BCA Assessment Report

**Sydney South West Private Hospital
Liverpool NSW**

**Prepared for Healthscope Pty Ltd
C/- Woods Bagot**

26th August 2010

HEALTHSCOPE SYDNEY SOUTHWEST PRIVATE HOSPITAL FLOOR PLANS - LEVEL 01

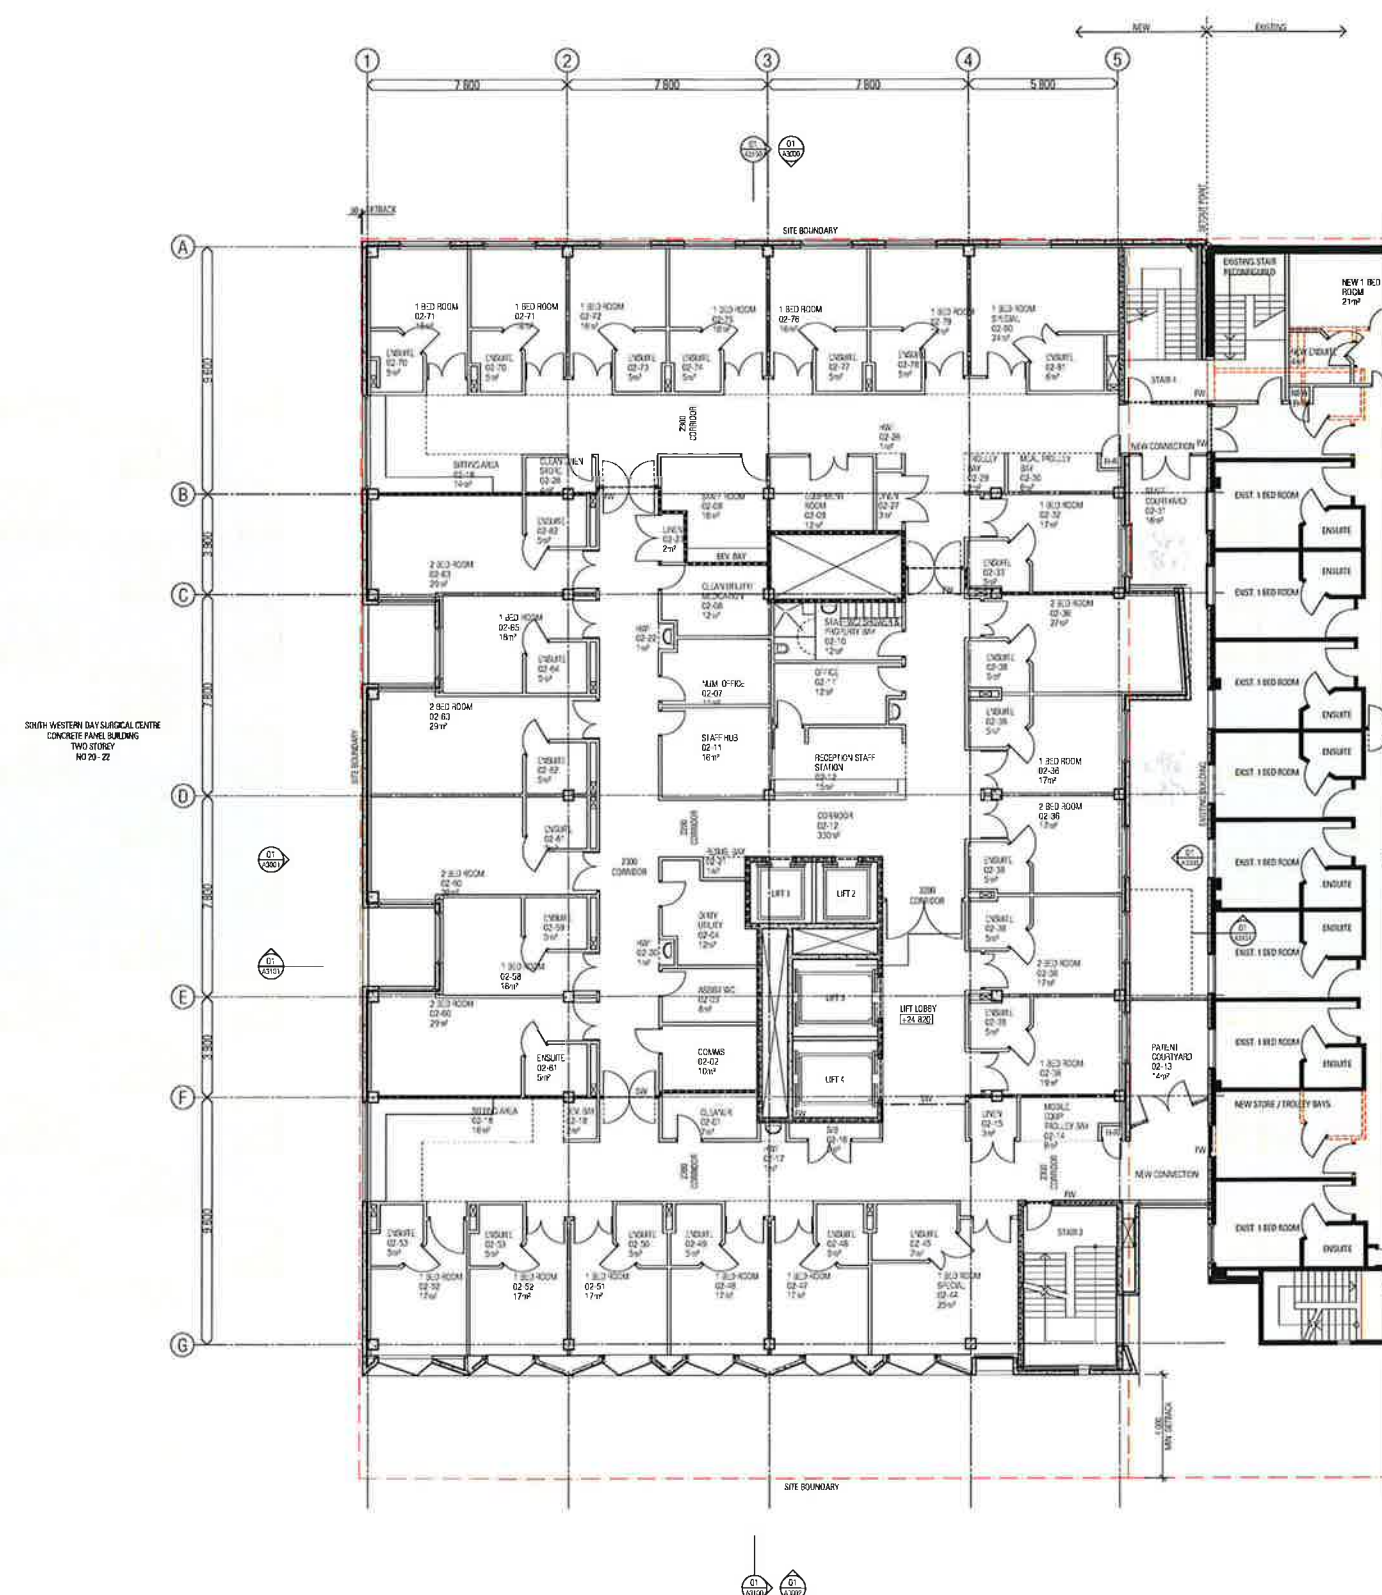
- Level 01 - excessive travel distances identified along the north-eastern side of the ground floor may be addressed by considering implantation of horizontal exits etc.
